# Comments for Planning Application CA/20/02636

Application Number: CA/20/02636

Address: All Saints Church Church Street Whitstable Kent CT5 1PG

Proposal: Installation of gate to church car park.

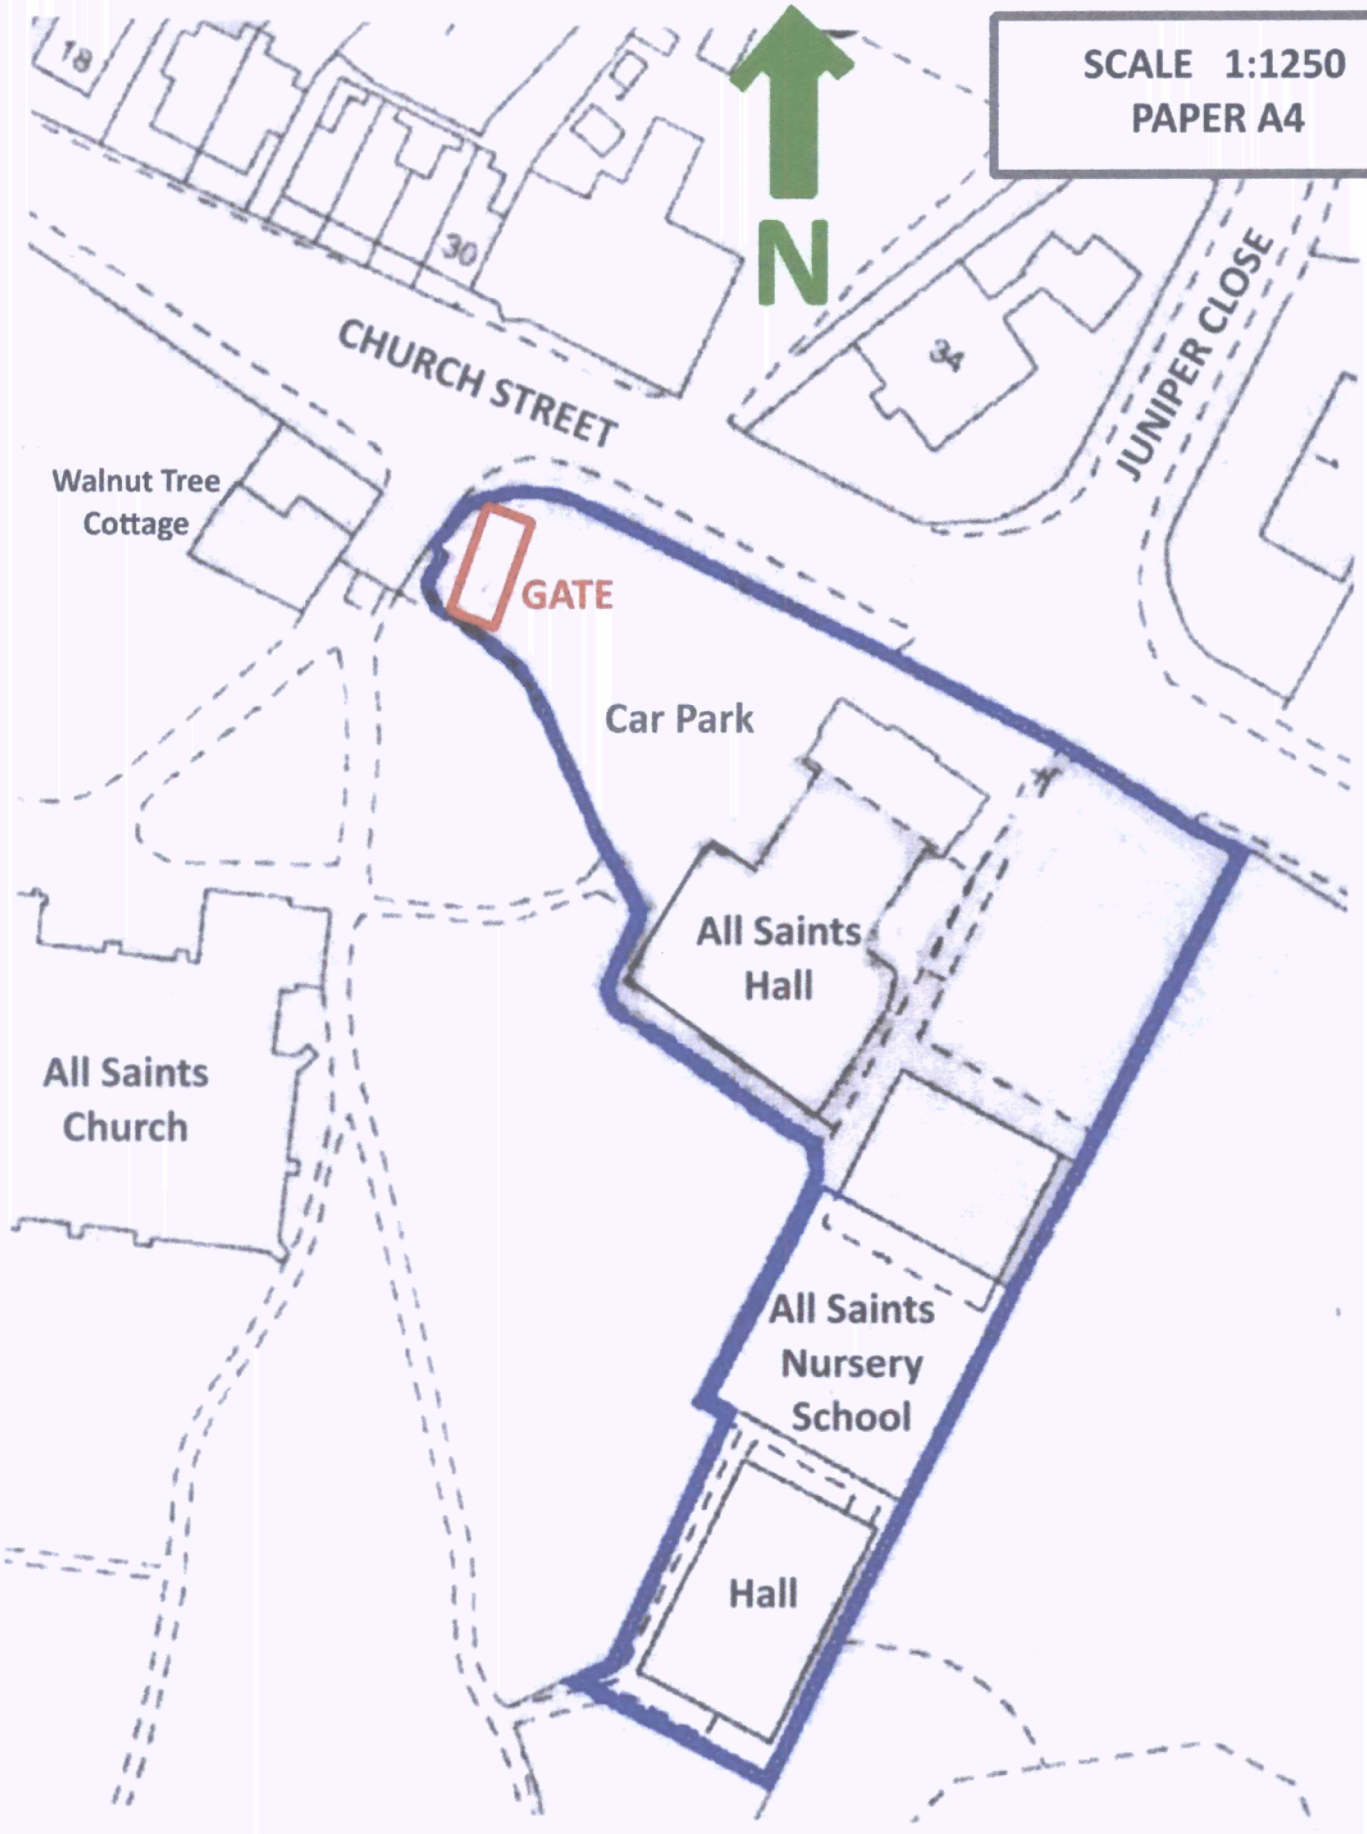
Comment: The proposed structure is ugly and is more in keeping with the film set of Shawshank Redemption rather than with aesthetics of All Saints Church and its environs, ie. the Conservation Area. Even if the gates were attractive, the proposal is impractical and potentially divisive.

Pollution would be a problem with engines running whilst people are opening and closing the gate to enter the Car Park.

Noise would be an issue with people stopping, exiting and entering their vehicles and slamming car doors and opening and closing the gate.

The knock-on effect could be dangerous, too, with elderly people having to exit and enter their cars to open and close the gate upon entering and exiting the Car Park. It has the potential to deter the elderly or infirm from visiting the graves of loved-ones.

Another danger could be if a small queue formed at the Car Park entrance and a vehicle turned the corner and drove straight into the queue as it is sometimes not possible to see around the corner when a vehicle is parked in front of the Bus Stop. It is very rare (practically unheard of) for cars to enter the Car Park at speed but I have witnessed two accidents at the junction of the Car Park and Church Street because of blind spots when cars are parked by the Bus Stop. If two cars are exiting and entering the Car Park at the same time there could also be problems.

Many young mothers with pushchairs coming from the Nursery or Church Hall walk across the Car Park as the pavement next to it (by the Bus Stop) is very narrow. They, too, would have to juggle with opening and closing the gate whilst looking after their little ones (as, too, with dog walkers - many of whom are elderly). NB : The Car Park is continually used as a safe walkway because of

Several youths from The Whitstable School walk home through the church grounds after school. They often stop in the lytch gate and play around in the area - letting off steam. I can see the potential of these gates being used as a climbing frame by these (and other) youngsters possibly leading to an accident if they show off a little too much. It's a concern and also a possibility.
